CITY OF ALBUQUERQUE

June 13, 2022

RE: 543 Old Coors Dr. SW
Grading and Drainage Plans
Engineer's Stamp Date: 06/11/22
Hydrology File: K11D027

Based upon the information provided in your submittal received 06/01/2022, the Grading & Drainage Plans **are not** approved for Building Permit, SO-19 Permit and Grading Permit. The following comments need to be addressed for approval of the above referenced project:

SECTION A PROFILE

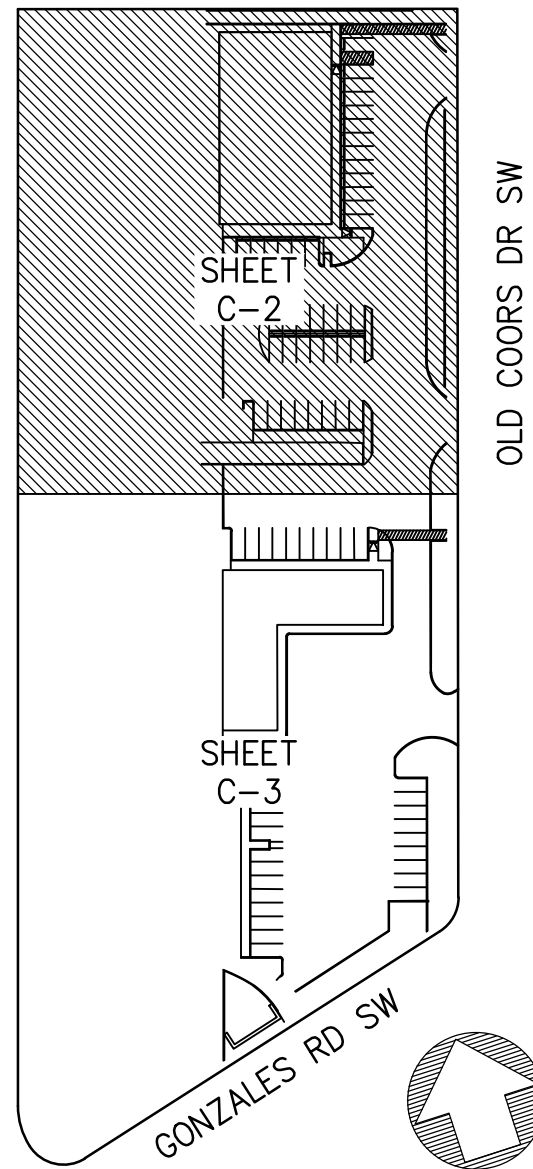
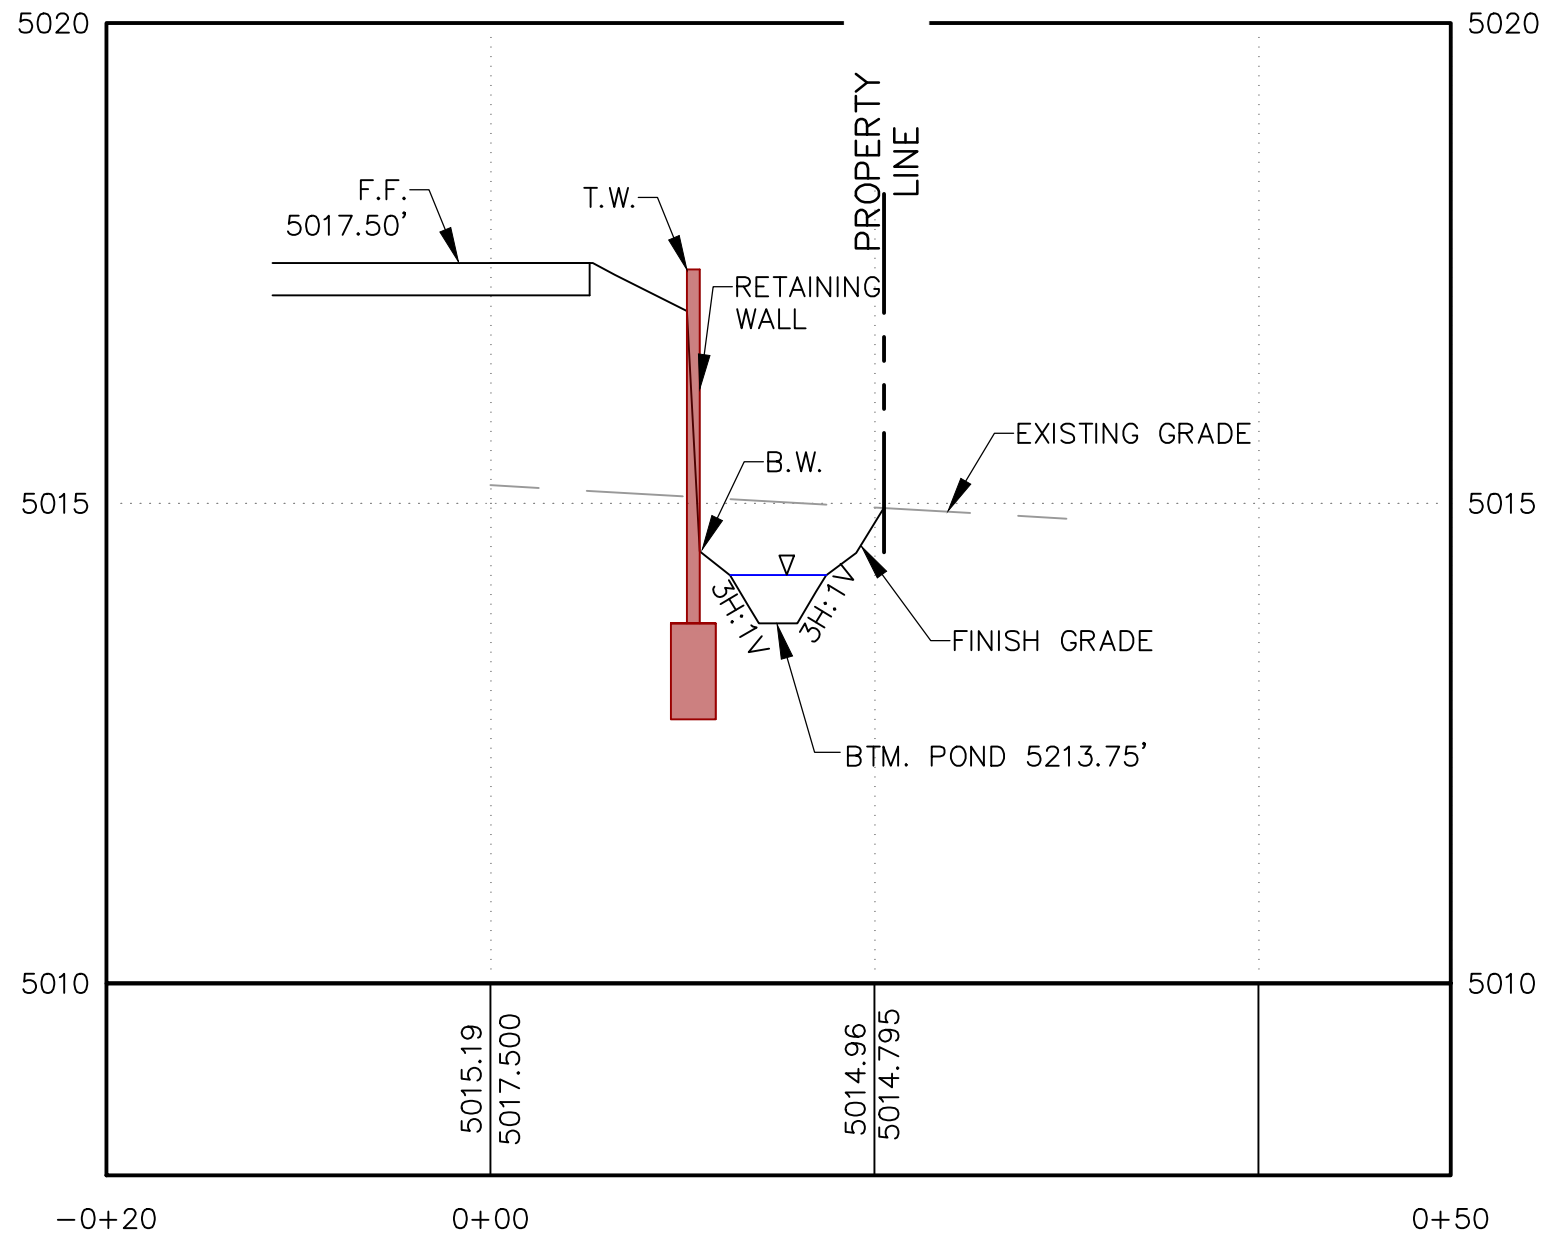
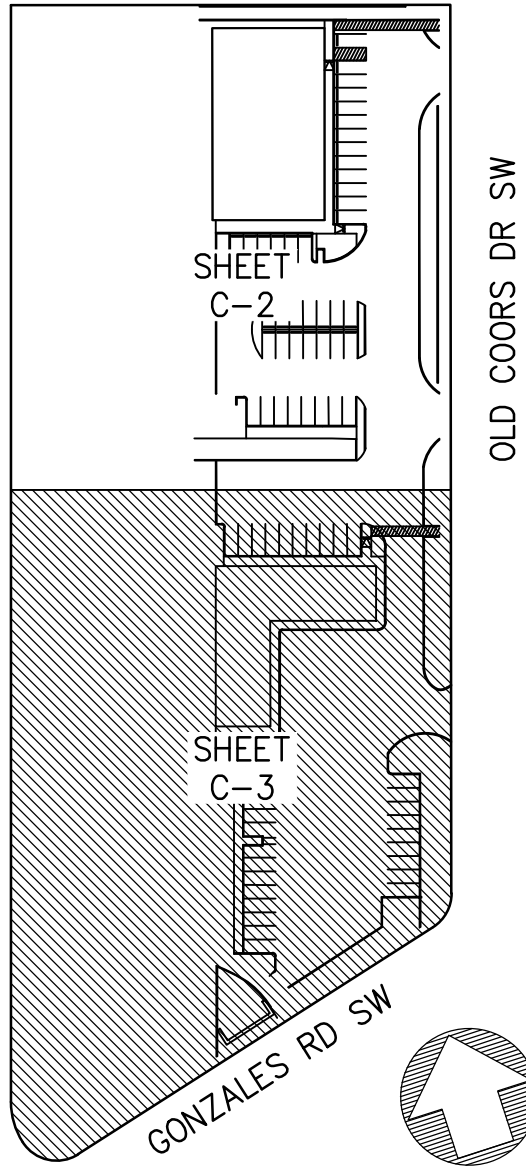
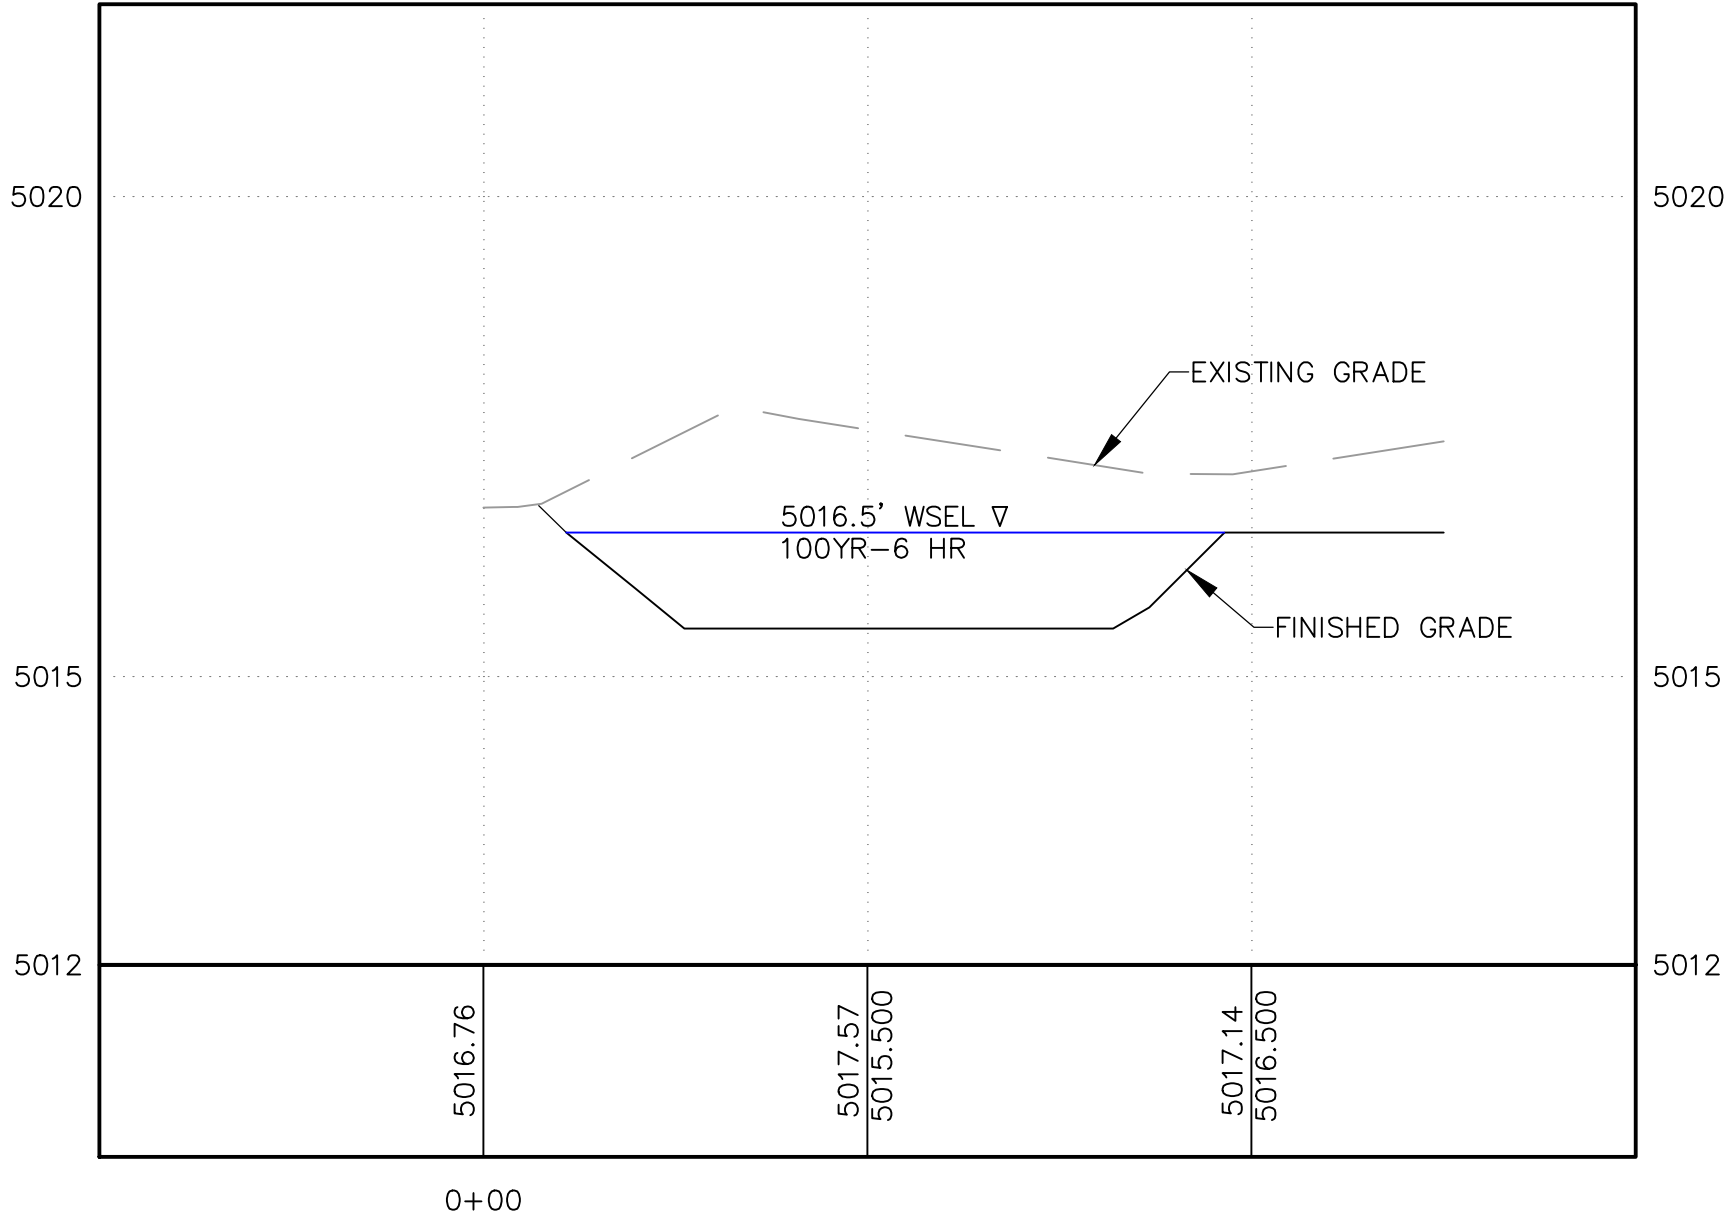
19. Please revise all the detention / stormwater quality ponds that have slopes greater than 3:1 side slope. Please see Comment #4.
20. Please add the note, "Side slopes need to be stabilized with Native Grass Seed per the City Specification with Aggregate Mulch or equal (Must satisfy the "Final Stabilization criteria" CGP 2.2.14.b.)".

**GRADING PLAN
DETAIL**

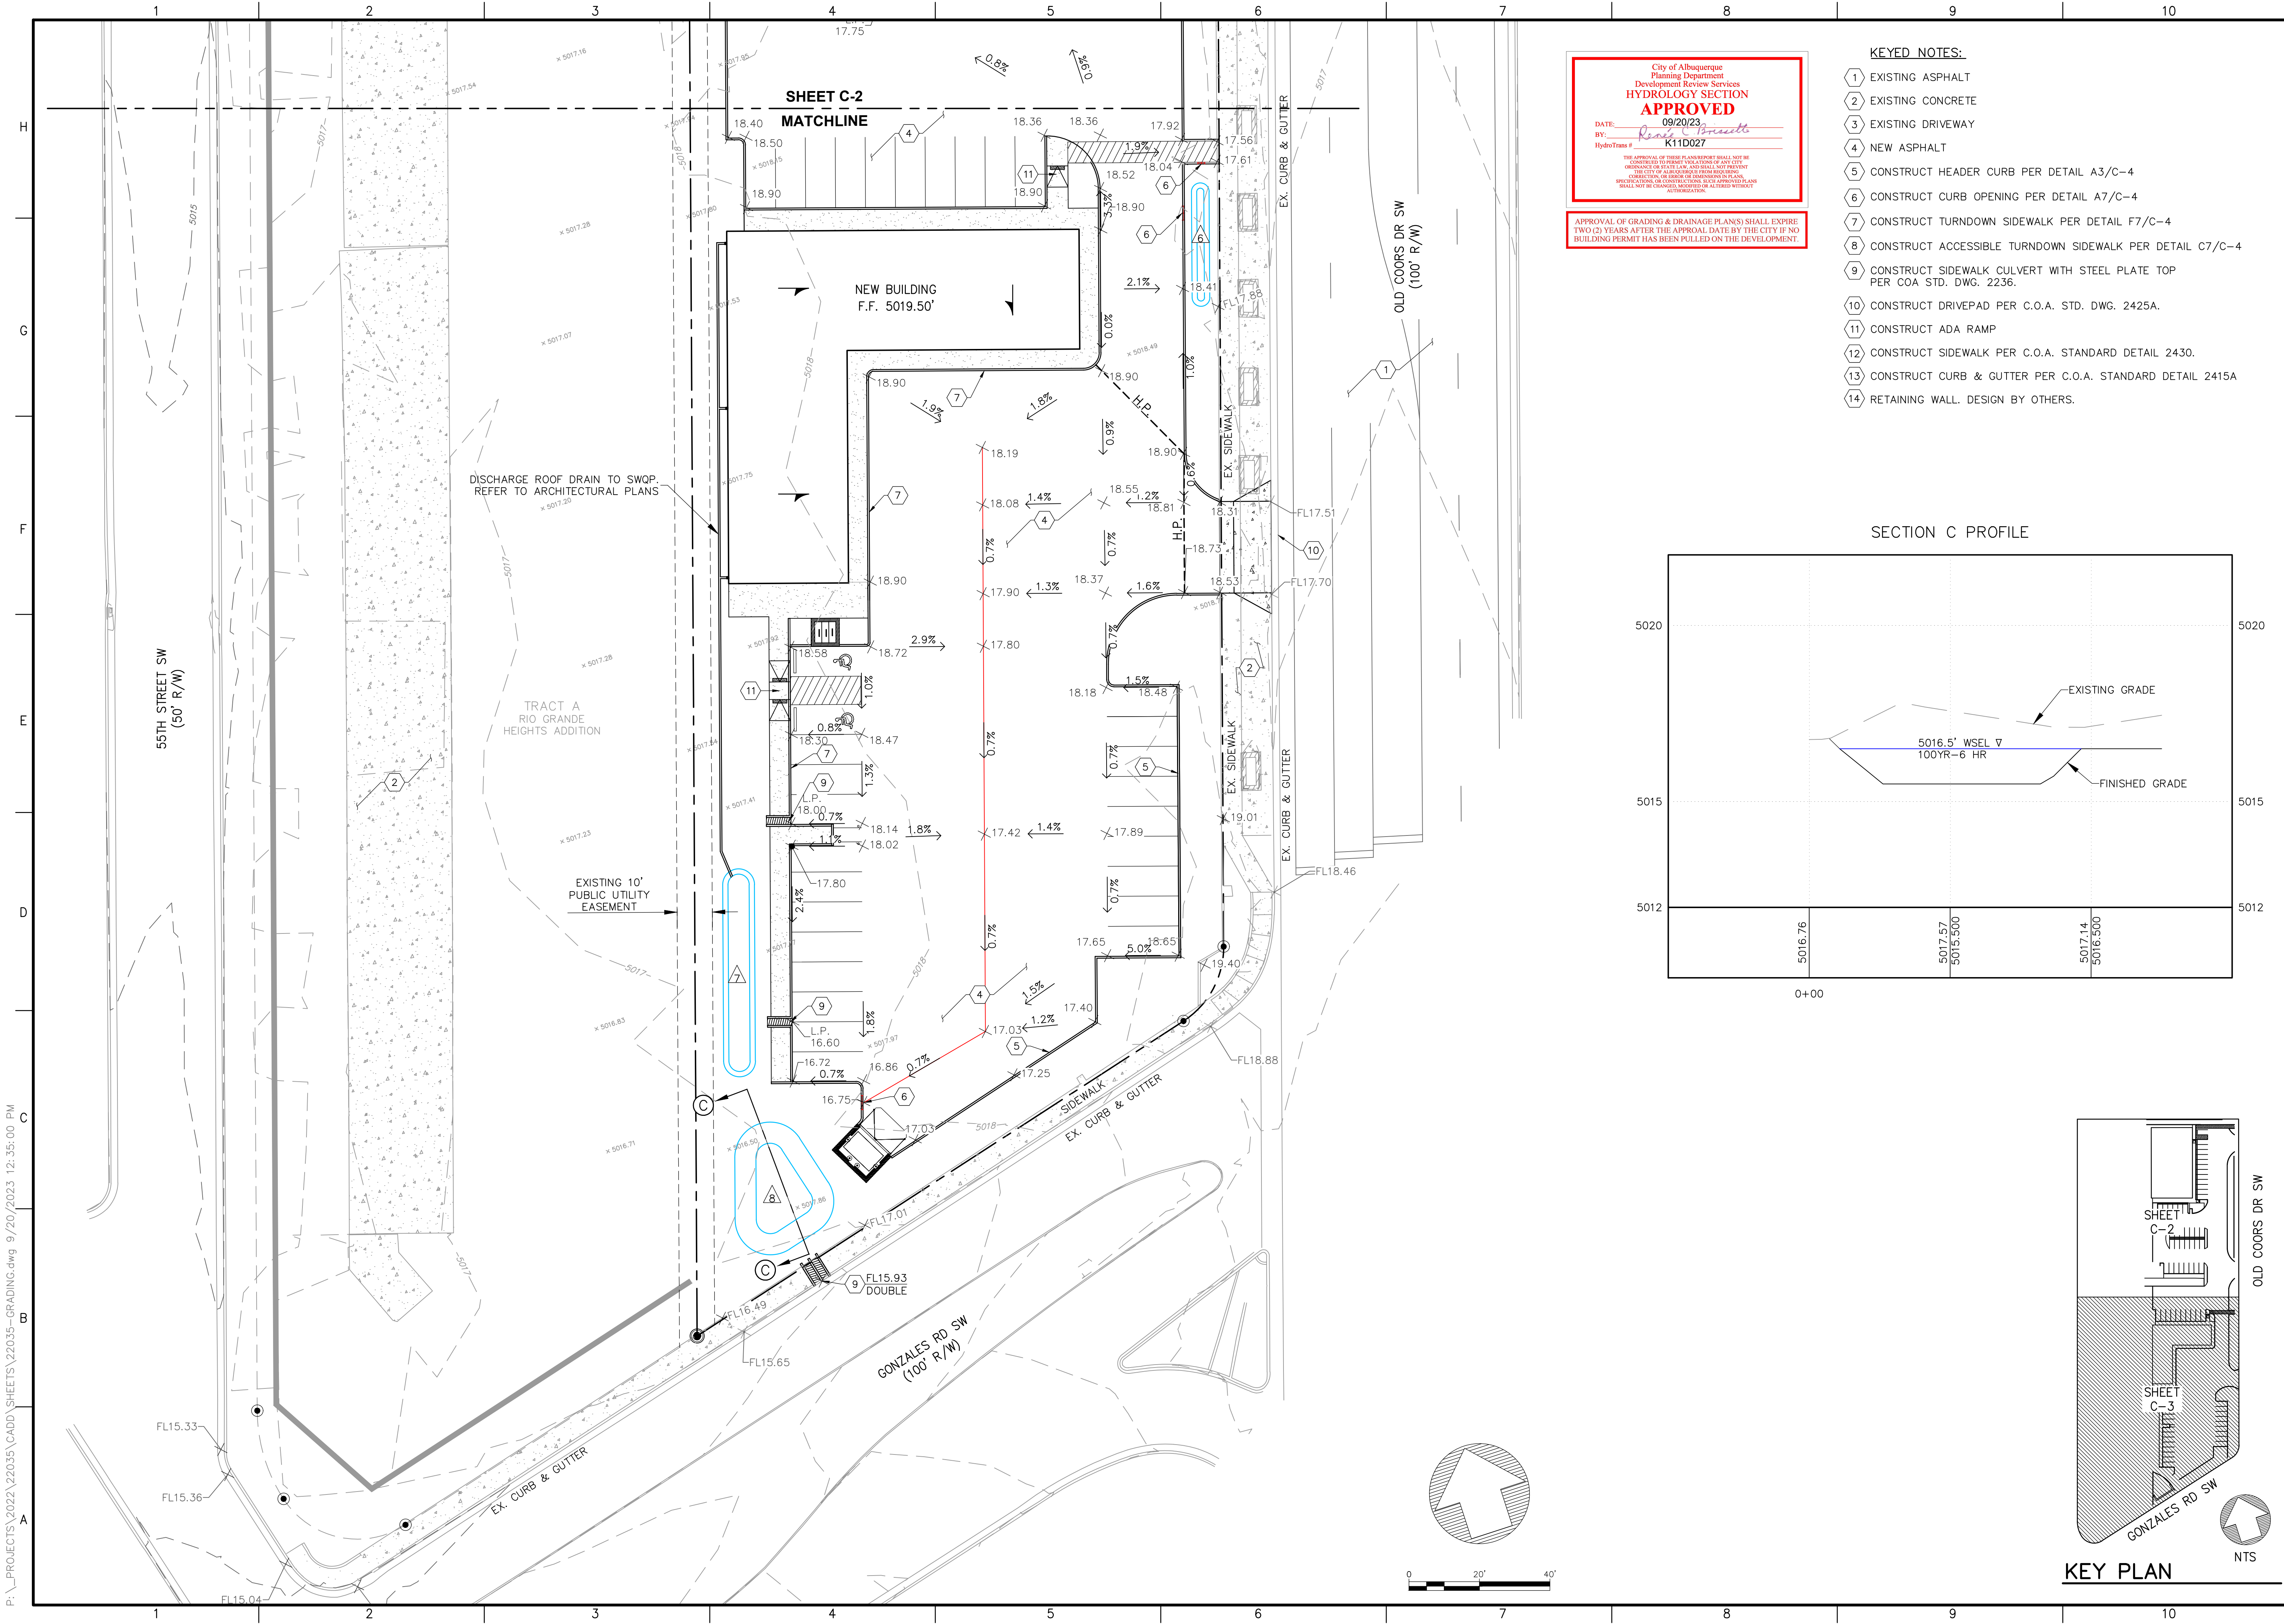
7. Please provide better detail on how this pond is being discharged into the sidewalk culvert. Also, please draw the sidewalk culvert correctly. The steel plates need to extend one foot into the property. The City does not allow more than three -2 feet culverts together. Again, please refer to the standard detail.

8. Please provide a detail for the wall opening. Also, please note that wall appears not to be stable and may need to be replaced.

9. Why is this portion of the parking over the property line and into Tract A? Also, where is the edge of the asphalt from the parking to the header wall?

10. The driveway that is not going to be used must be removed and new curb & gutter and sidewalk shown to be installed.

11. How is this detention /stormwater quality pond being discharged? There needs to be some sort of spillway / outfall for it. Please revised.

12. How is this detention /stormwater quality pond being discharged? There needs to be some sort of spillway / outfall for it. Please revised.
